Your Ref:
Our Ref: TR010018
Date: 27 January 2015

Application by the Highways Agency for an Order Granting Development Consent for the A14 Cambridge to Huntingdon Improvement Scheme

Advice following issue of acceptance decision

**A14 EASTBOUND MAINTENANCE ONSLIP WORK NO. 5 - WORKS PLANS SHEET NO. 7 (GENERAL ARRANGEMENT SHEET NO. 5)**

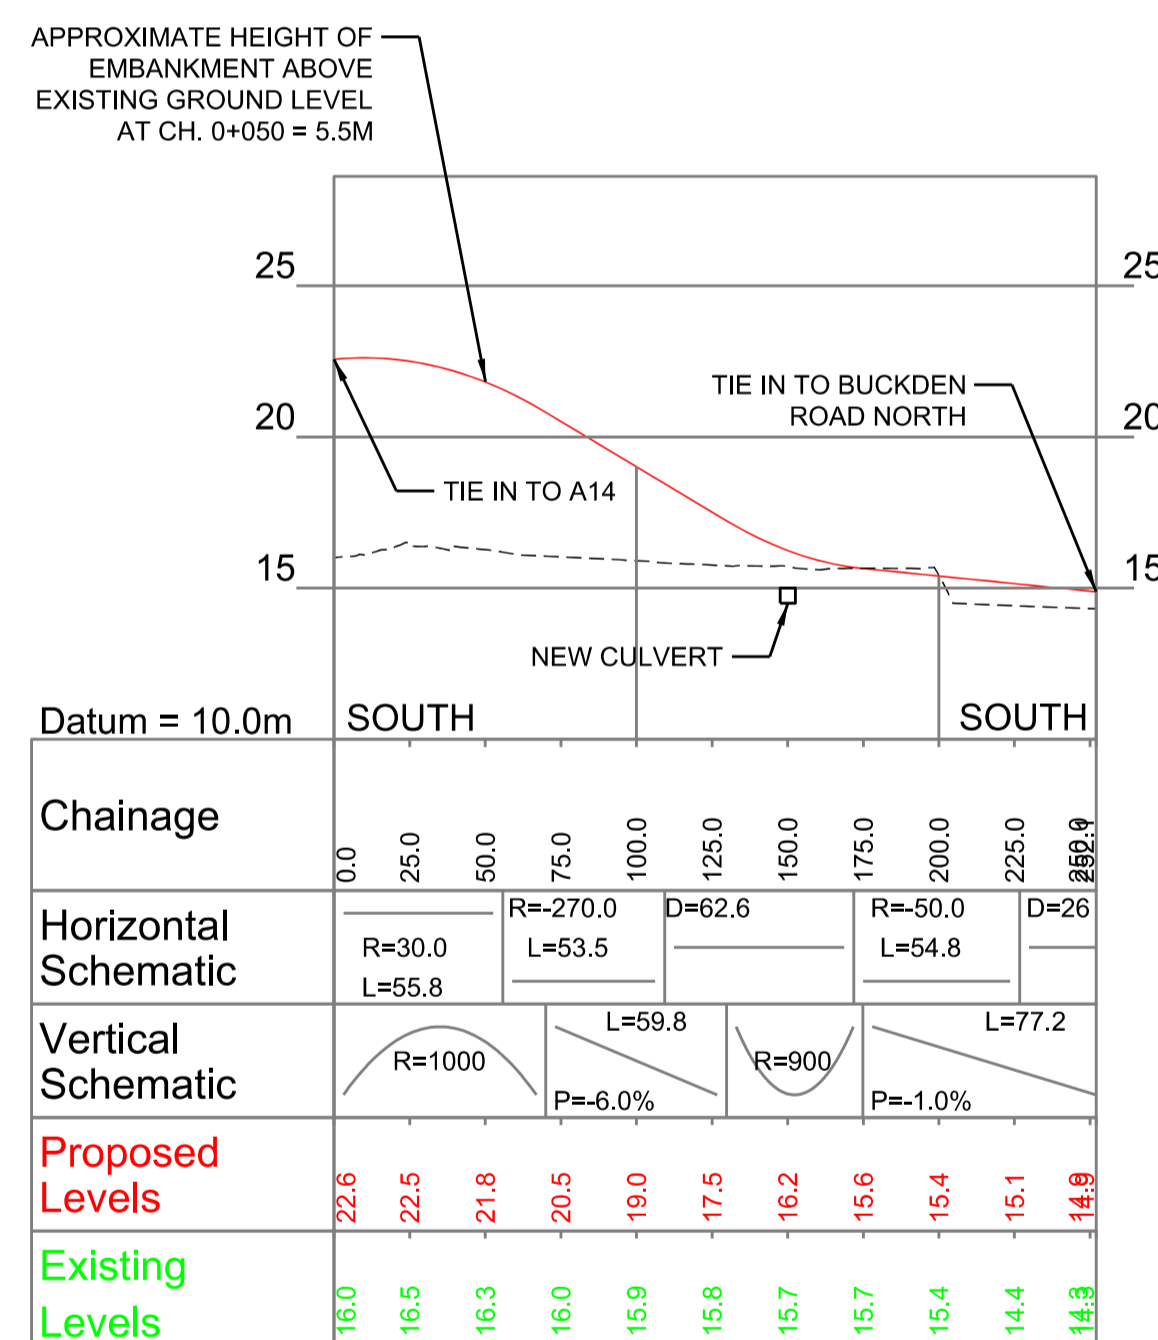
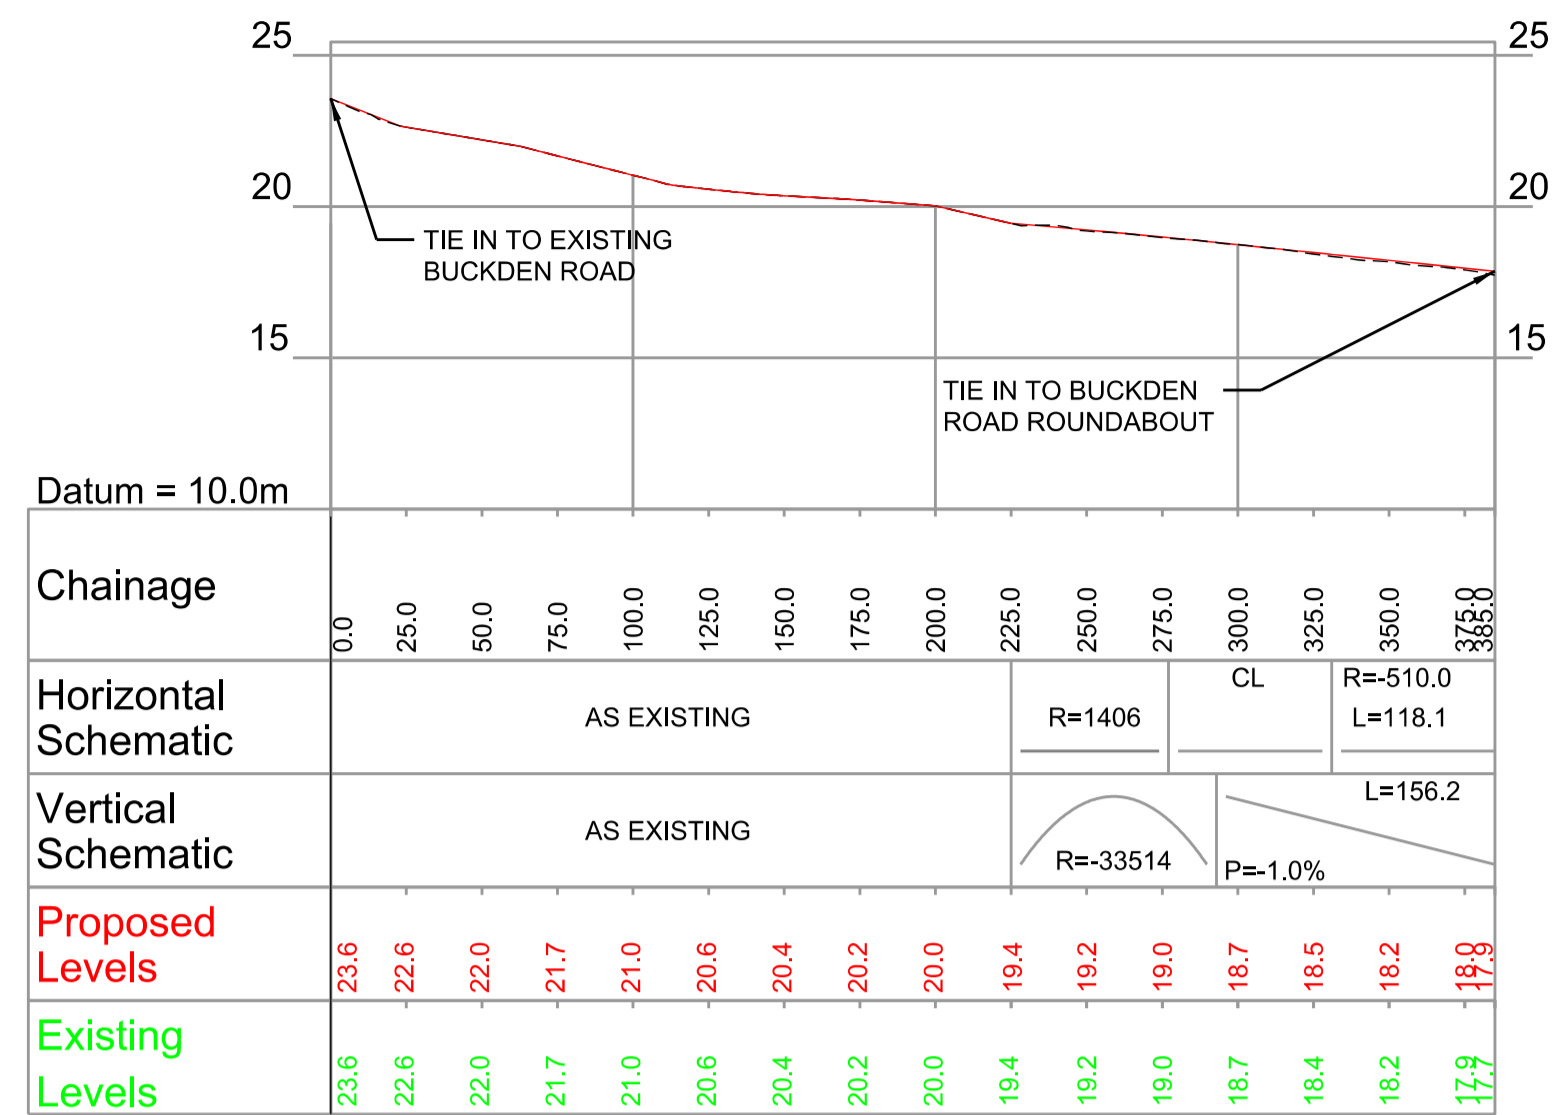
The Section Drawings can be difficult to follow as they do not appear to proceed in a logical order. Referencing the sections to Works Plans is also problematic, as frequently the features shown in section do not appear on the Works Plans.

A number of labelling errors have been listed in the s55 checklist which should be corrected. Where a number of similar works exist in proximity, such as in Huntingdon Town Centre, a map could be provided to identify them. The Inspectorate also considers that the ends of each section line could be labelled East/West etc as the aspect is not consistent.
